From: chris [REDACTED]
Sent: 09 January 2012 14:34
To: Katherine Rawlins
Cc: Tom Barnes
Subject: 6-8 London Road, Bognor Regis.
Attachments: Prop GF Plan 1 Model (1).pdf; Prop FF Plan Model (1).pdf

Following our discussion this morning, I have spoken to the client regarding concerns raised by the Environmental Health section on the location of the Disabled WC.

PROPOSED FIRST FLOOR PLAN

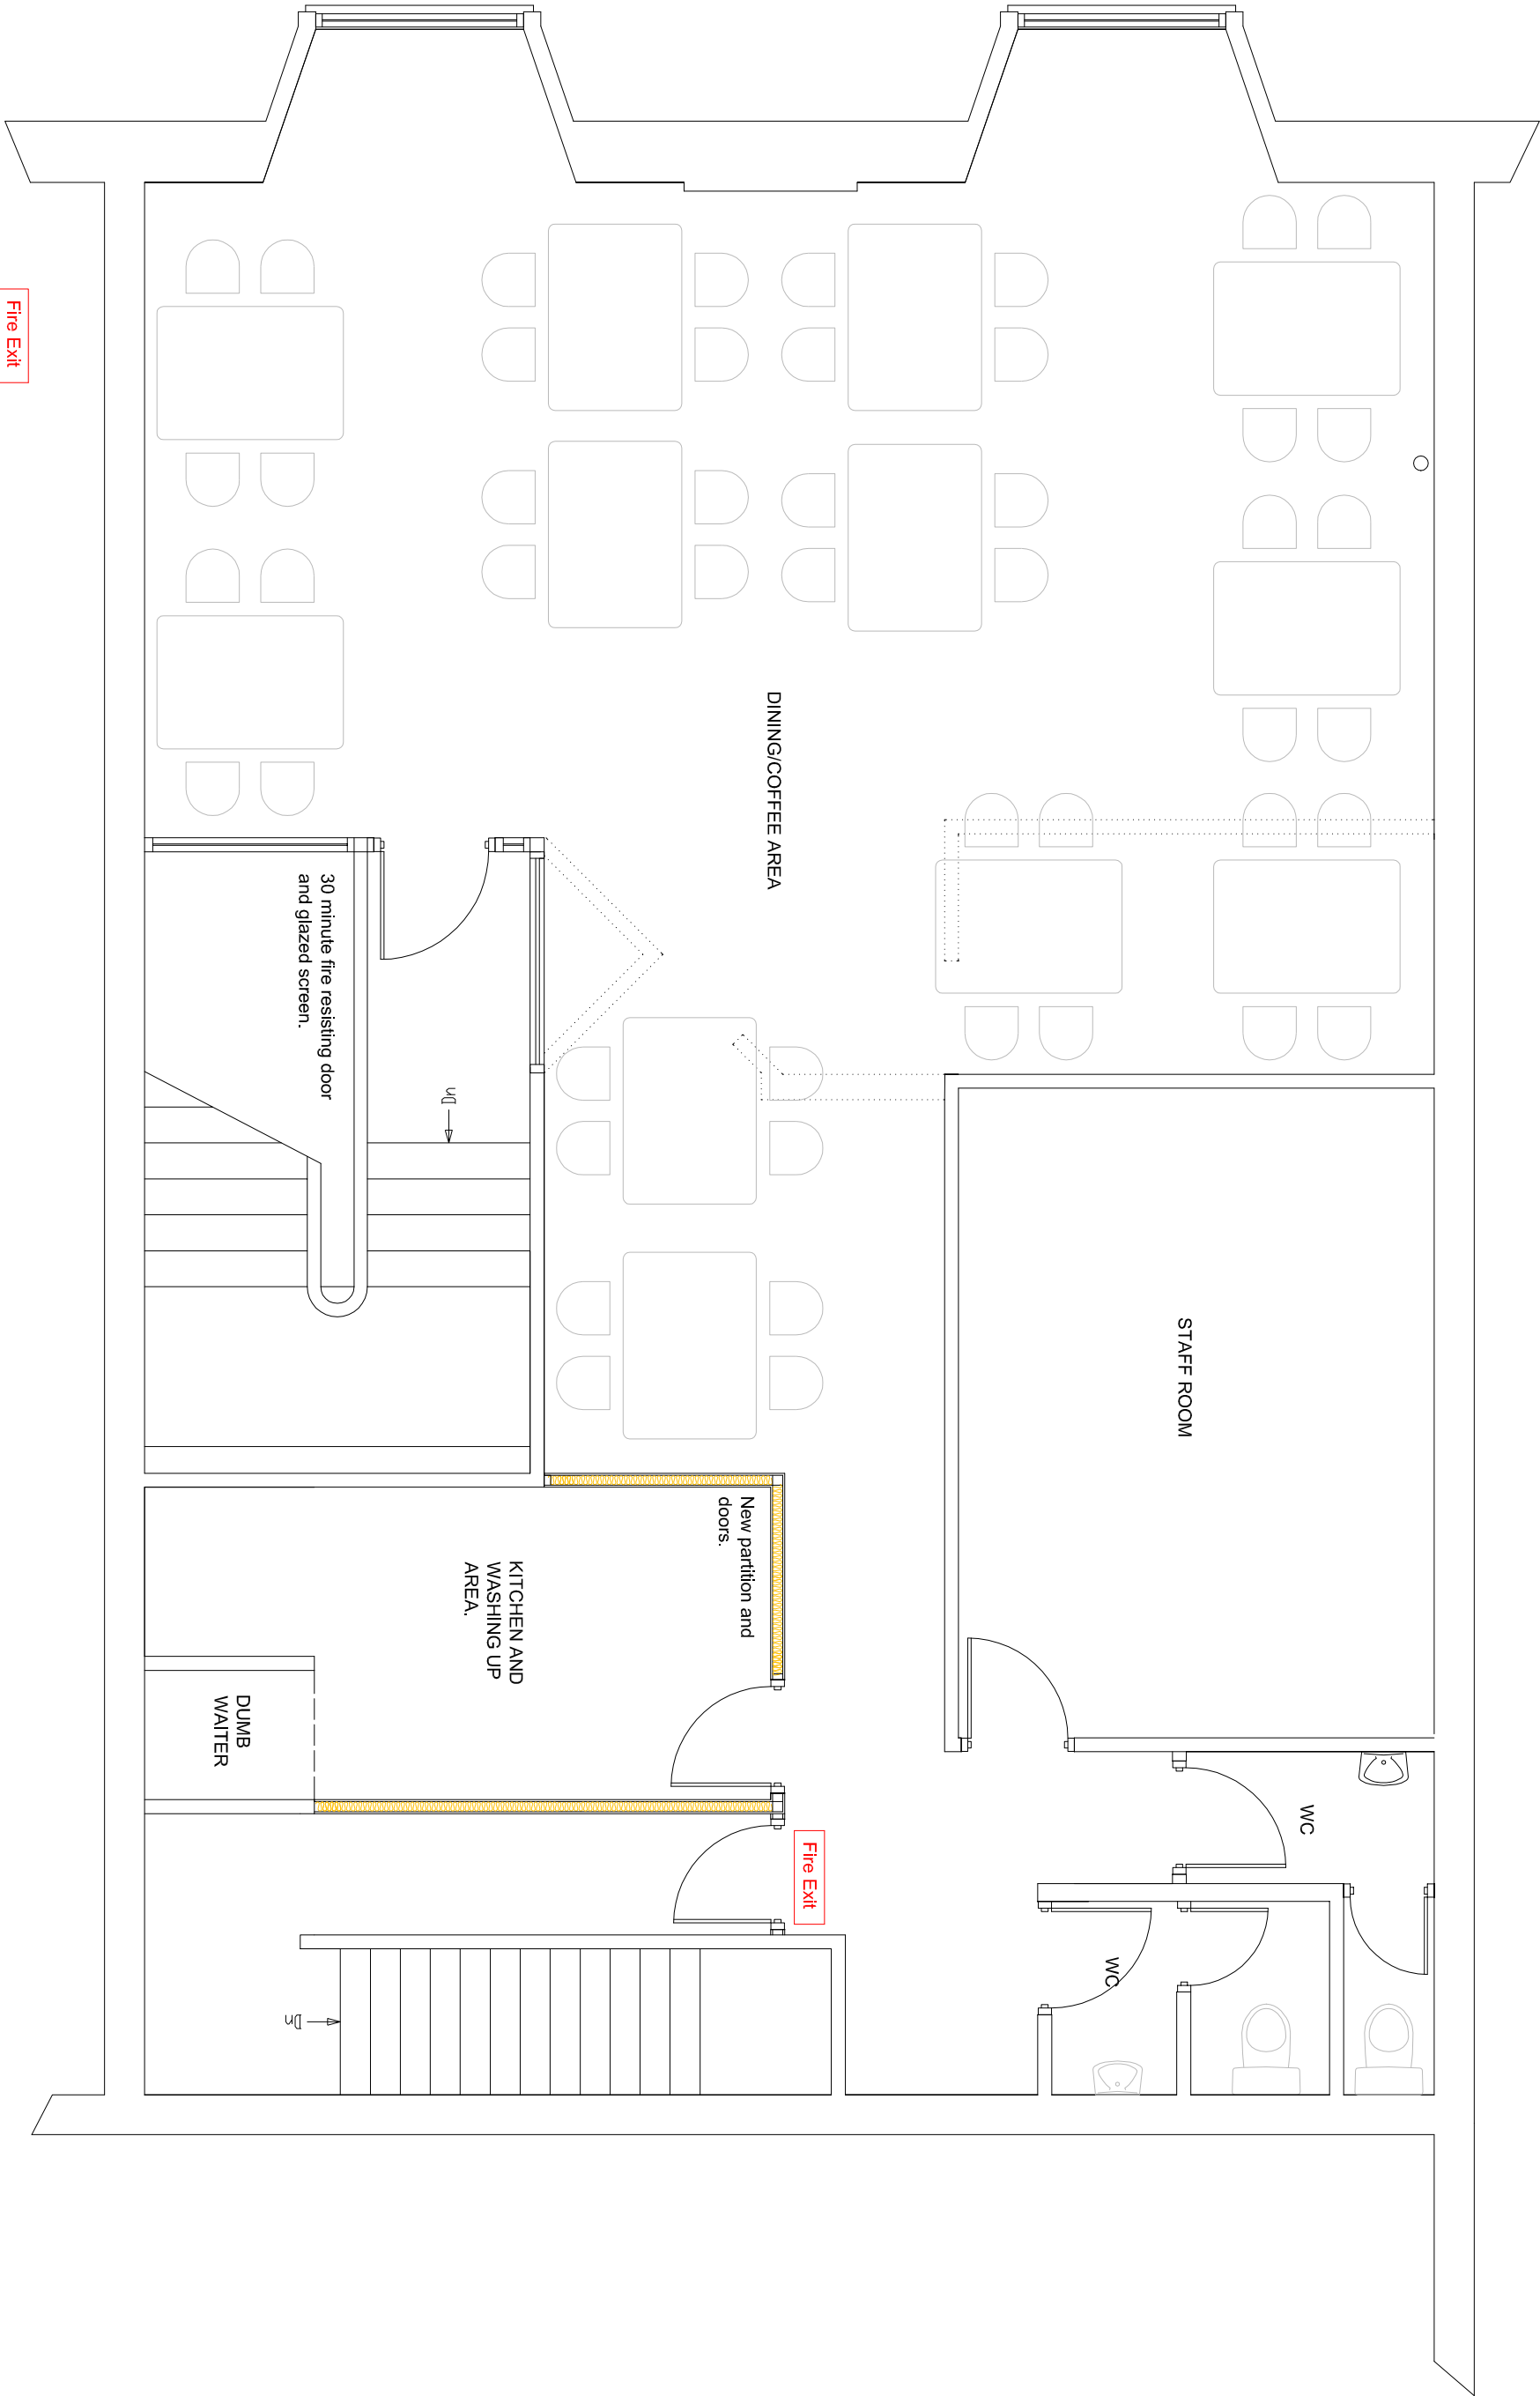
I have also shown where the refuse bins are to be placed and likewise the staff room on the first floor is now a food storage area. Please let me know as soon as possible if there is any other information required.

PROPOSED GROUND FLOOR PLAN

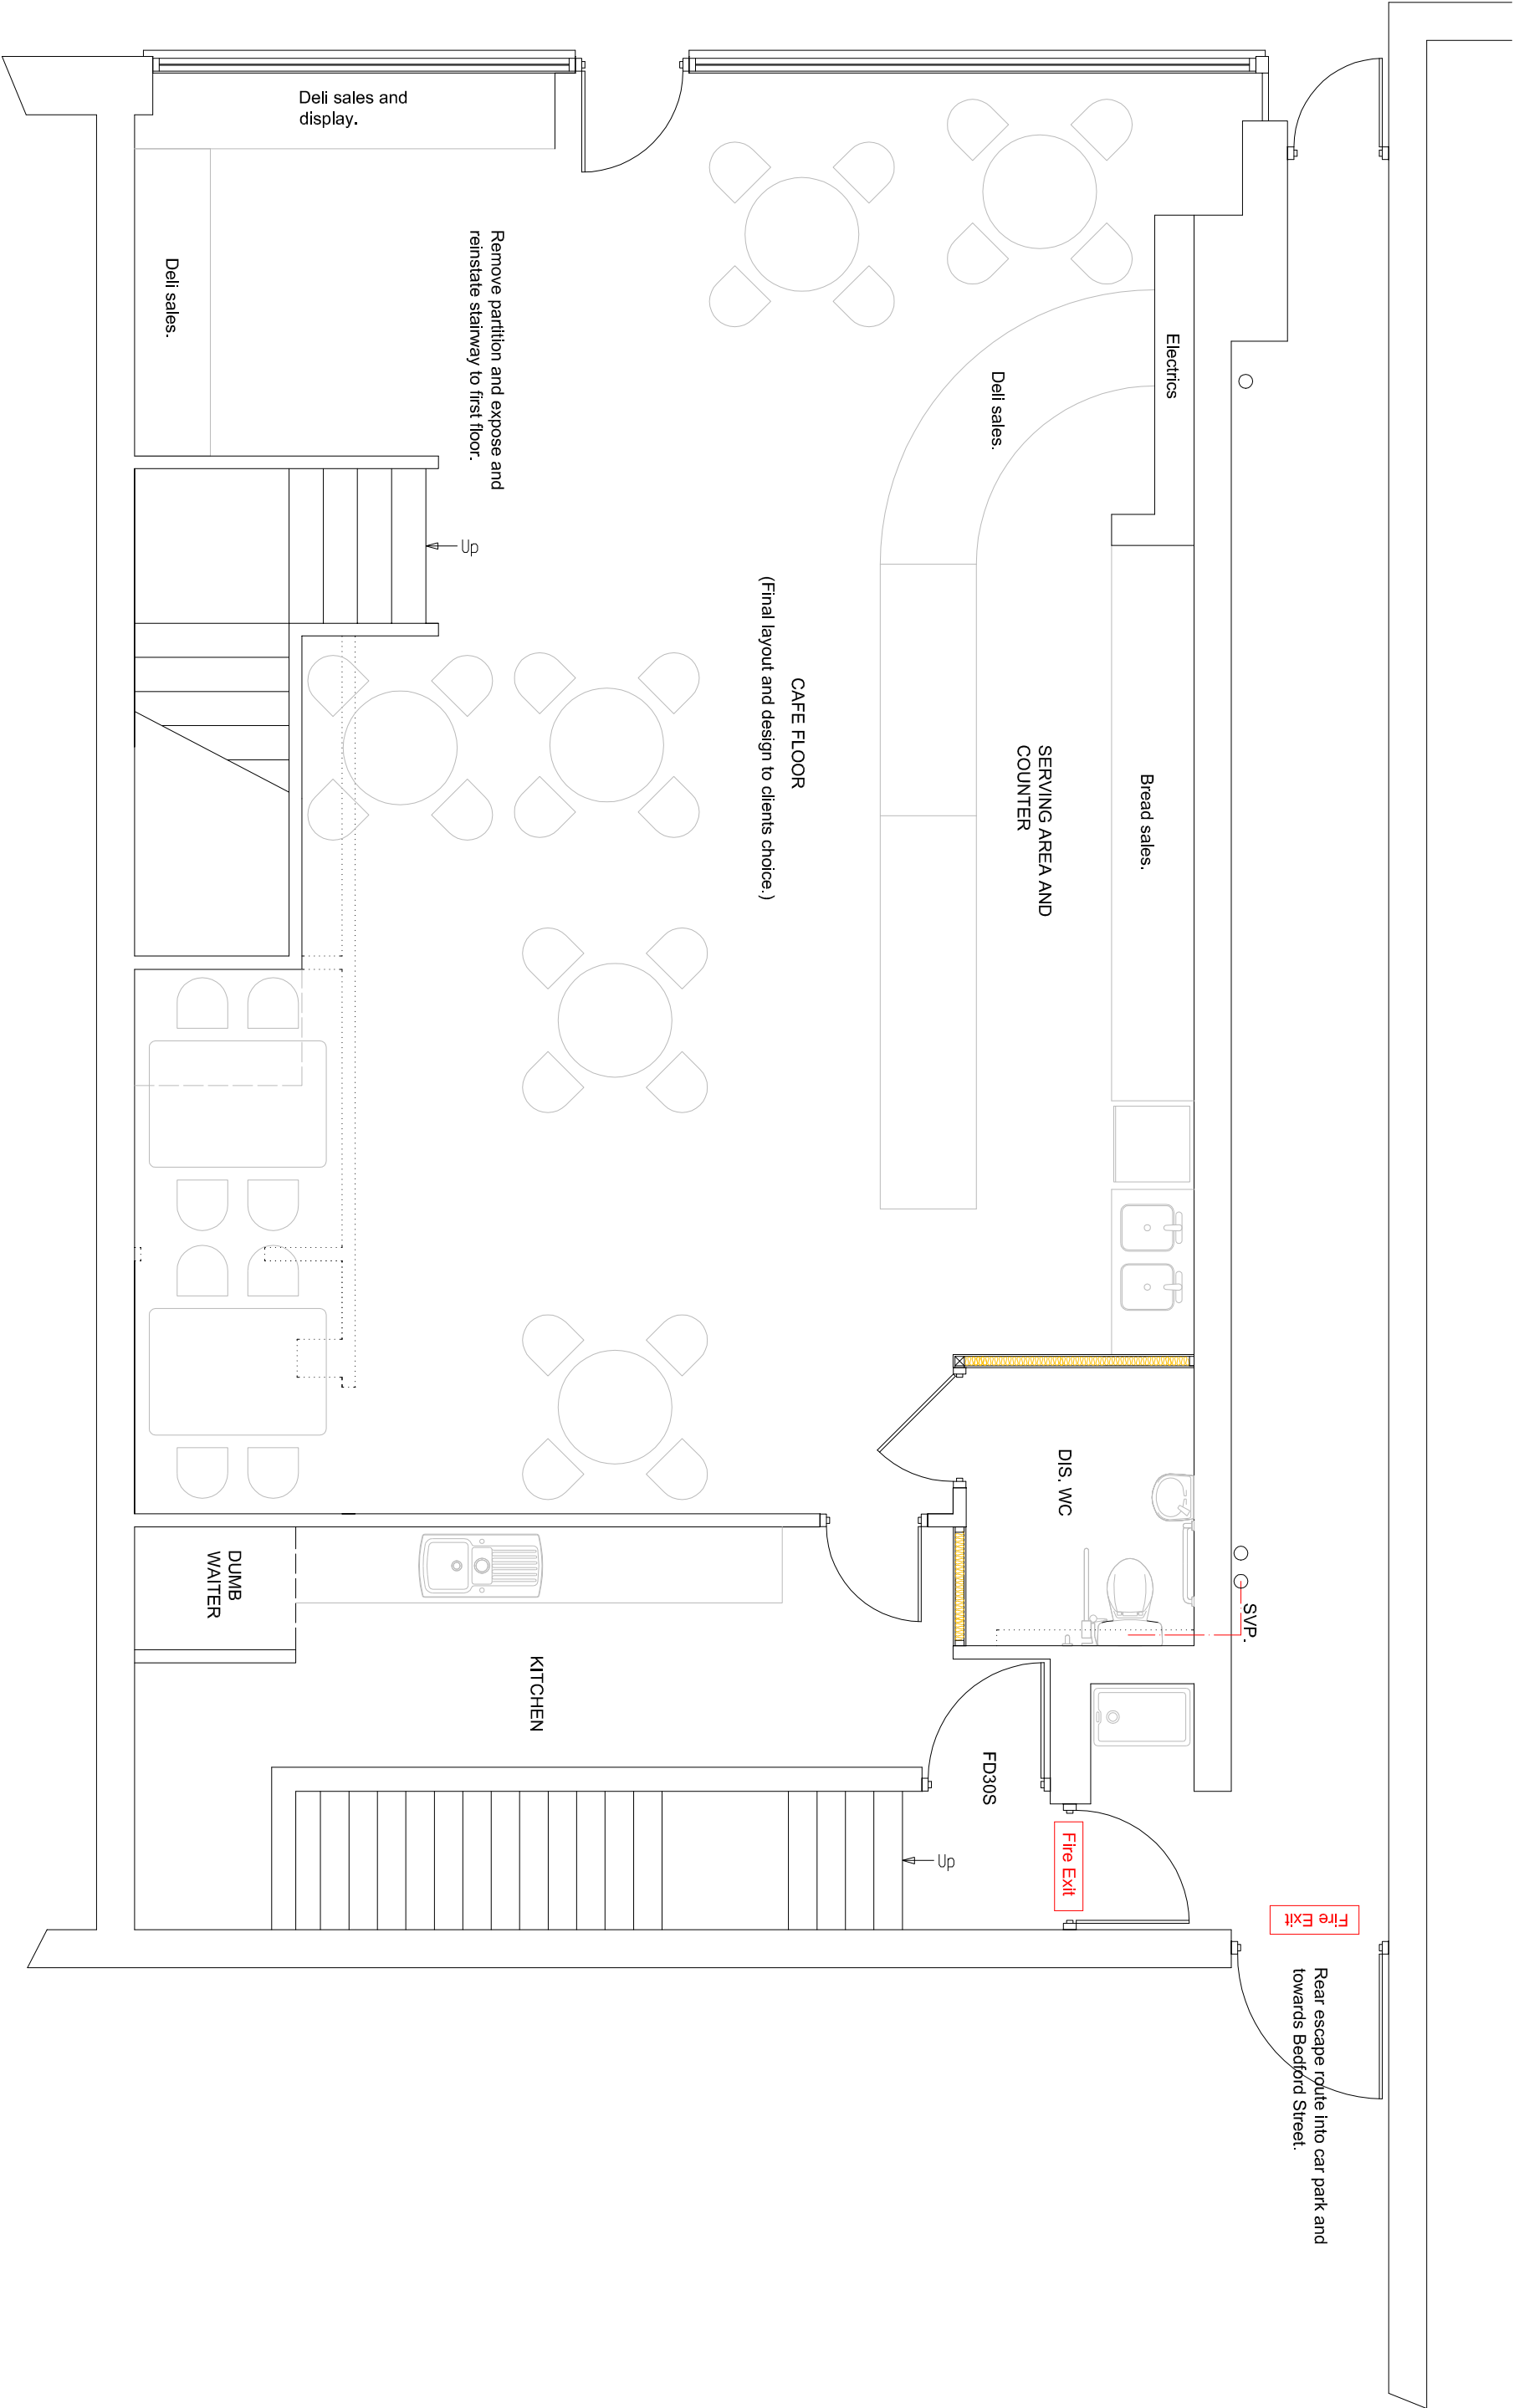
I would stress that the relocation of this facility is integral to opening up the café more than the current layout allows and that the client dearly needs it in the area shown. To that end I have moved the door to the kitchen away from the WC and placed a lobby between the WC and the café area. I hope that this is now acceptable and look forward to receiving confirmation of the fact.
